CITY OF ALBUQUERQUE

January 30, 2015

**RE: Estates at Glendale Unit 2
Drainage Report and Grading and Drainage Plan
Engineer's Stamp Date 1-5-15 (File: B19D027)**

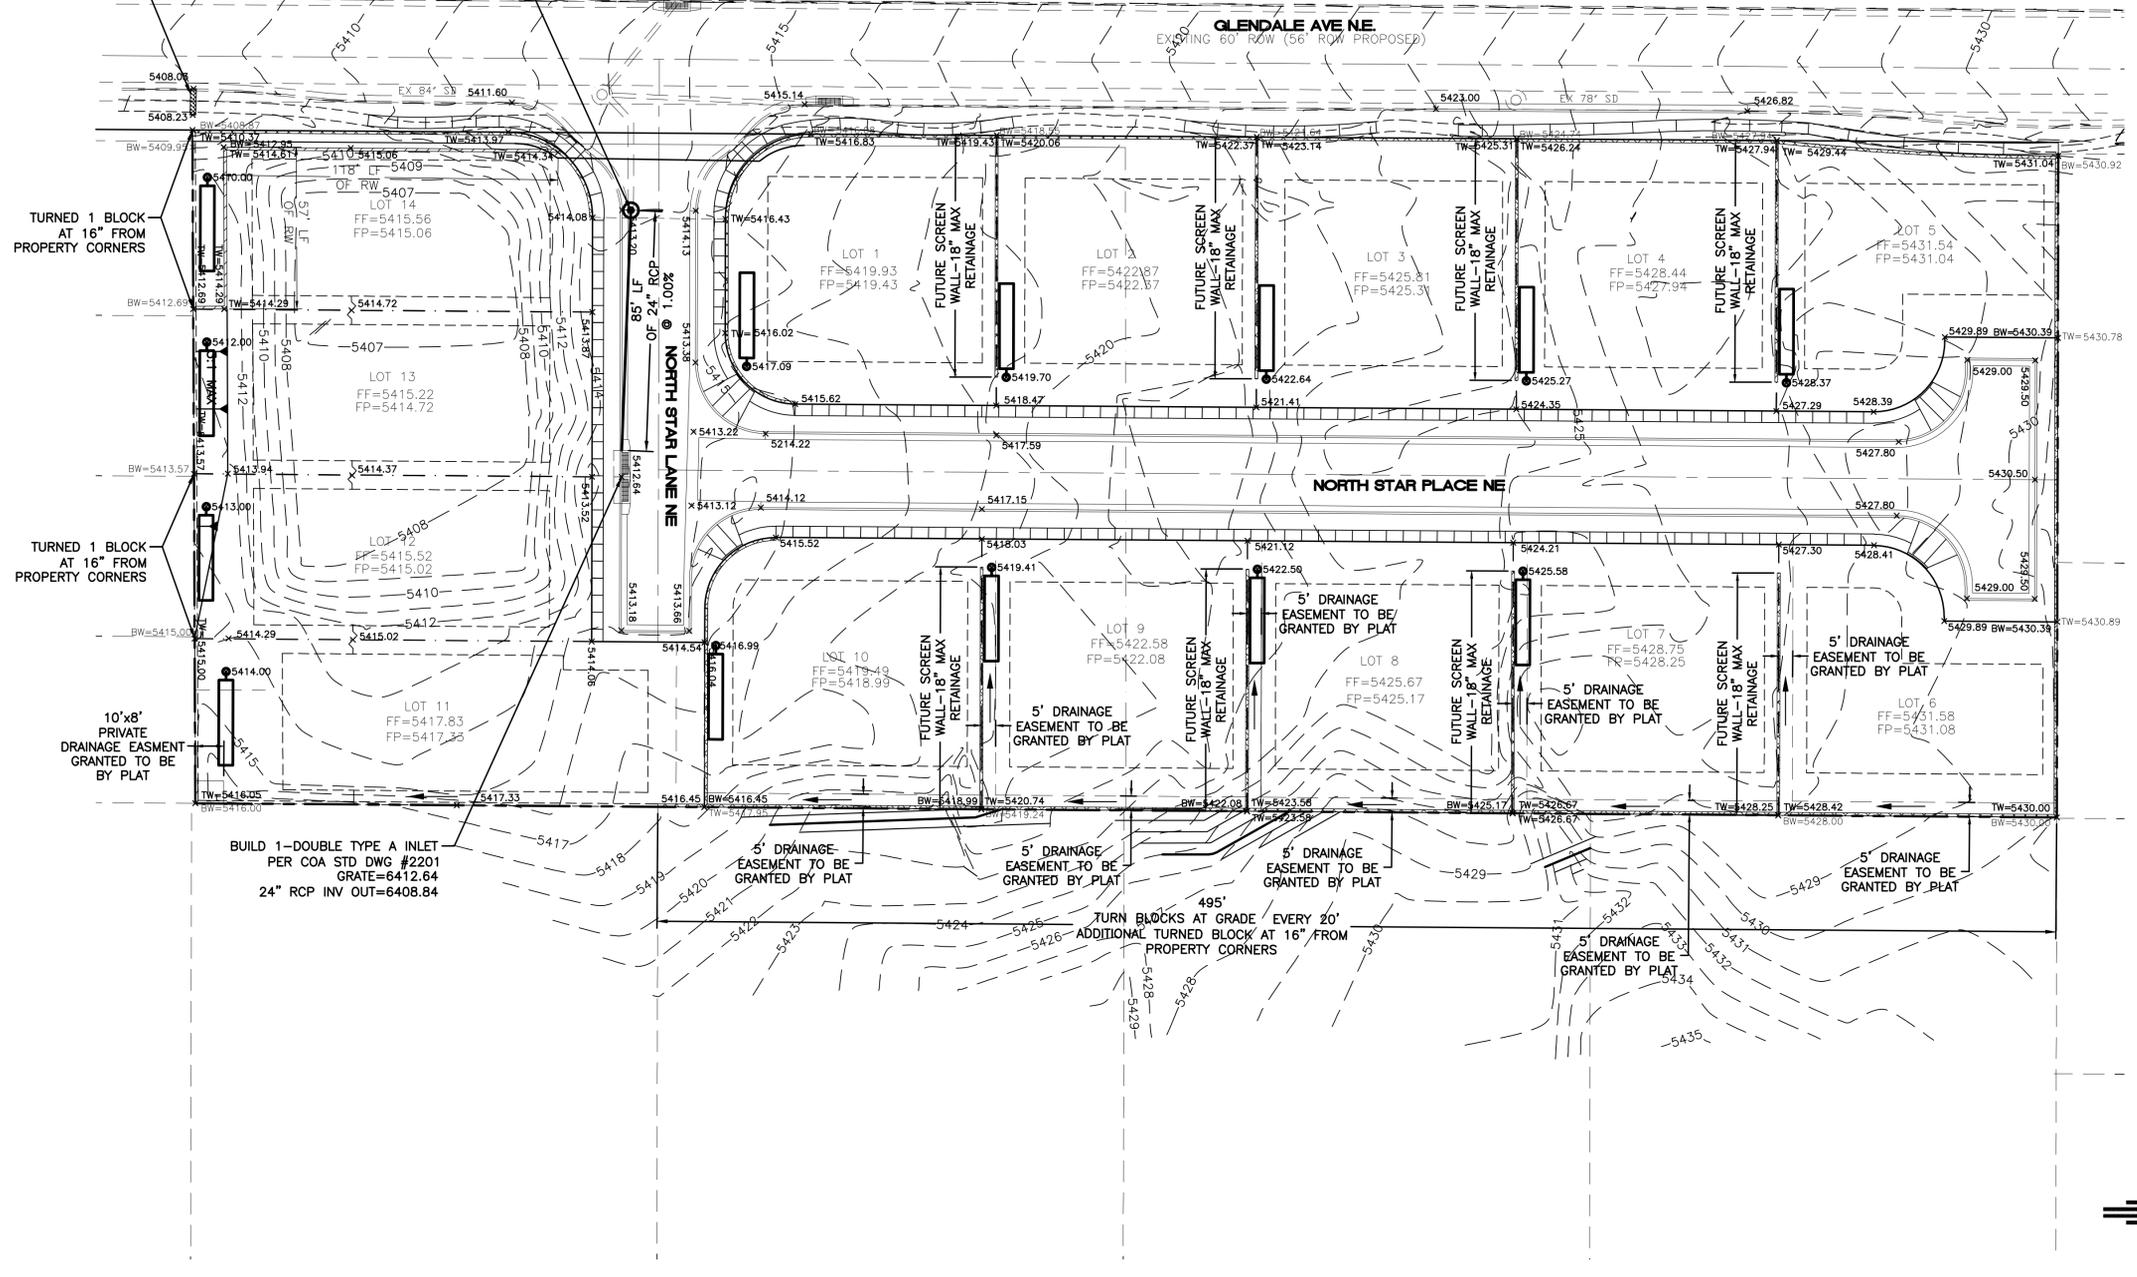
1. Existing concrete channel in SW corner is about 8' long (along existing wall) and about 5' wide (when scaled off the as-builts, but should be field verified). Show as a drainage easement on plat and note the channel dimensions on the Grading plan. Indicate with a flow arrow that it collects offsite flows from Lots to the South.

2. Note on the Grading plan any existing walls adjacent to the property. Note also any new walls to be constructed with this project. It is unclear where the existing walls are, particularly along the west and south edge. There also appears to be an existing wall along the east edge.

4. Basin B has 100% D in the spreadsheet for flow calculations. Error?
5. If there is to be "recontouring" on the lots to the south, then show on the plan and add the following note: CONTRACTOR MUST COORDINATE GRADING ON OFFSITE LOTS WITH NEIGHBOR(S) TO THE SOUTH PRIOR TO BEGINNING WORK

6. Provide a quick calculation showing the capacity of an overturned block.
7. For Lots 6 thru 10: Side lot drainage easements to be 10' wide. The 5' drainage easement along the wall is sufficient.

10. Wall along western boundary is noting overturned blocks but appears to be pointing to the existing wall. Move arrowheads to point to property lines between lots.

11. Provide overturned blocks in Retaining wall in back yard of Lot 14.
12. Show flow arrows at back of lots 11 thru 14.
13. Show TW and BW elevations at ends of retaining wall at back side of Lot 14, where wall is along Lot 13 property line. Can lot 13 drain into this area?

14. Show a spot elevation in that low area behind the retaining wall in Lot 14, particularly near the wall adjacent to the ROW to ensure it drains to an overturned block in that wall. Show other spot elevations between the retaining walls running east/west.

15. Show how the above mentioned discharge thru the overturned block will get to the SW culvert in the ROW. Provide a detail on the plan. Will a concrete channel work. *The plat must have a note stating that the owner of Lot 14 will be responsible for maintain the channel.*

16. Show the existing wall along western boundary and note that it is an existing garden wall (per the Glendale Phase I as-builts). Since it is not retaining, change the TW = XX.XX to FG = XX.XX, and remove the BW=XX.XX elevations.

21. Note the type of Curb and Gutter on the plan, and the extents of the different types.
22. Once the higher land treatments are used per comment 17, the total peak discharge to the sump will increase and the 24" pipe may need to be upsized.

24. Street capacity calcs on North Star Lane uses $Q=3.64$ cfs. How is this determined?
25. Show TW/BW elevations at end of retaining wall, at east side of Lot 14.

26. Turn off layer showing vacated ROW along Lot 14.
